Issue Specific Hearing – dDCO Friday 8<sup>th</sup> December.

Appendix C – Hedgerow Removal Plans

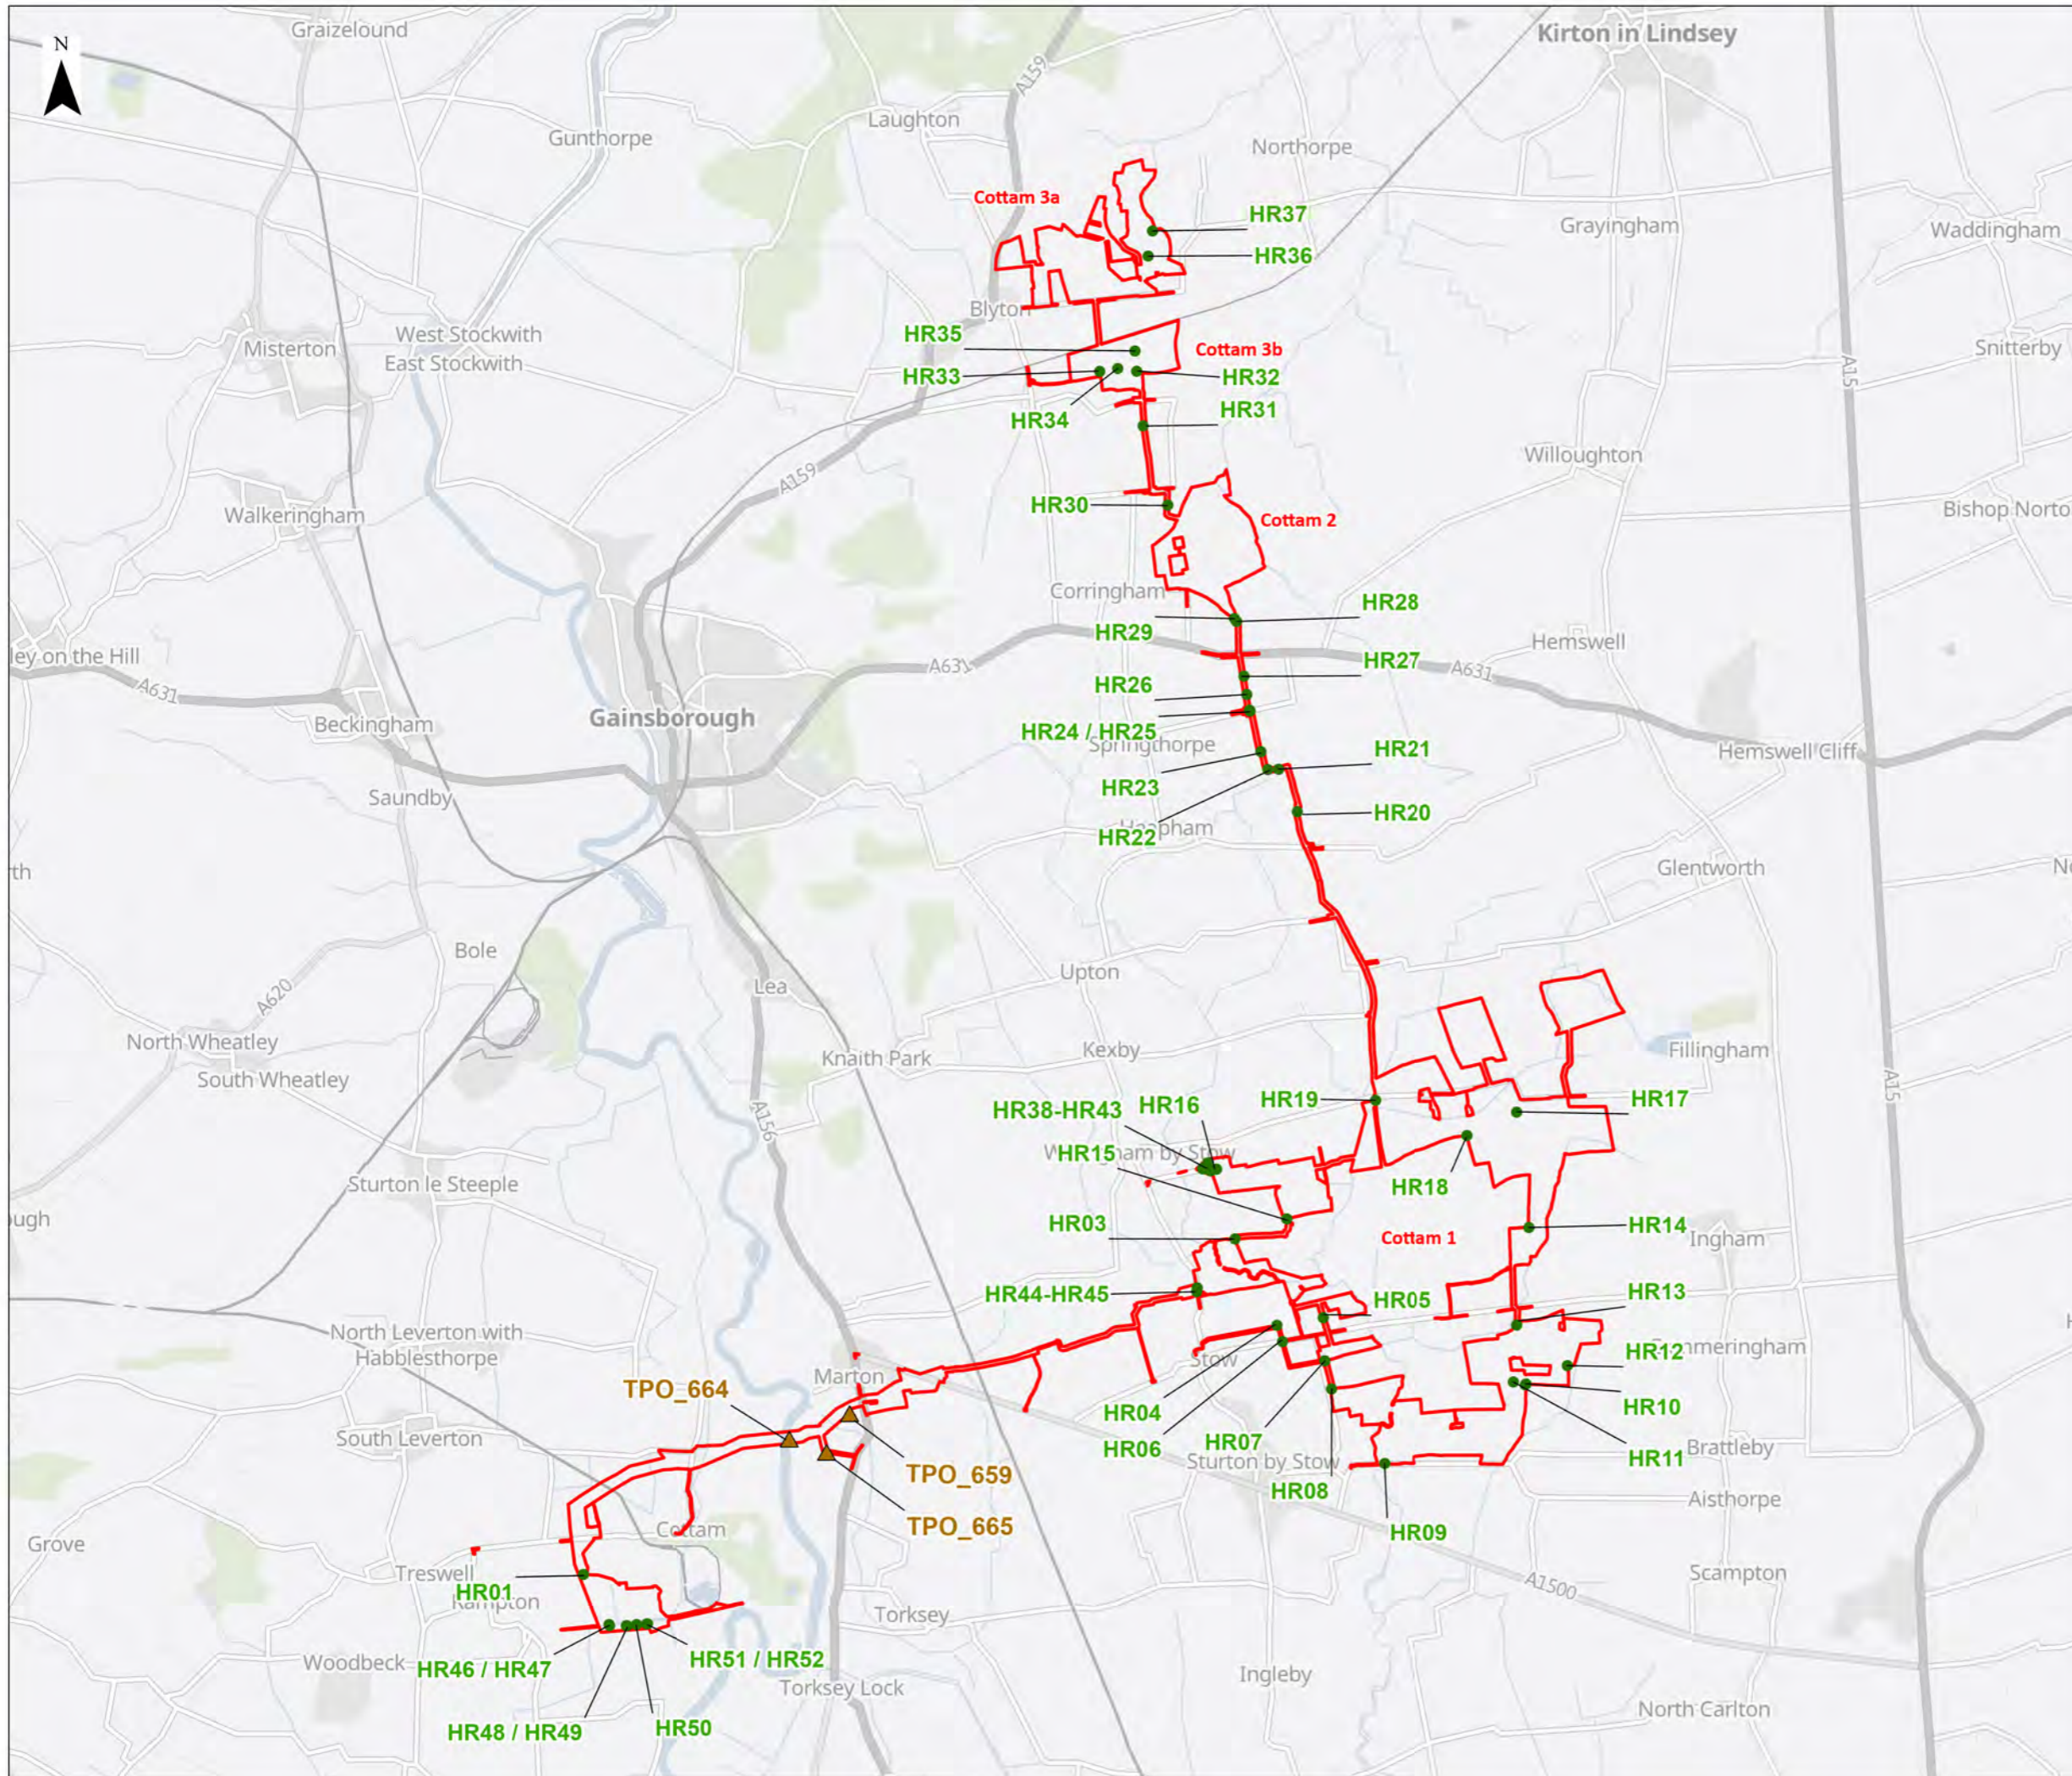
The hedgerow along Thorpe Lane, Sturton by Stow is not within the solar array but has been identified within the dDCO. Could any part (or all) which may need to be removed be highlighted please.
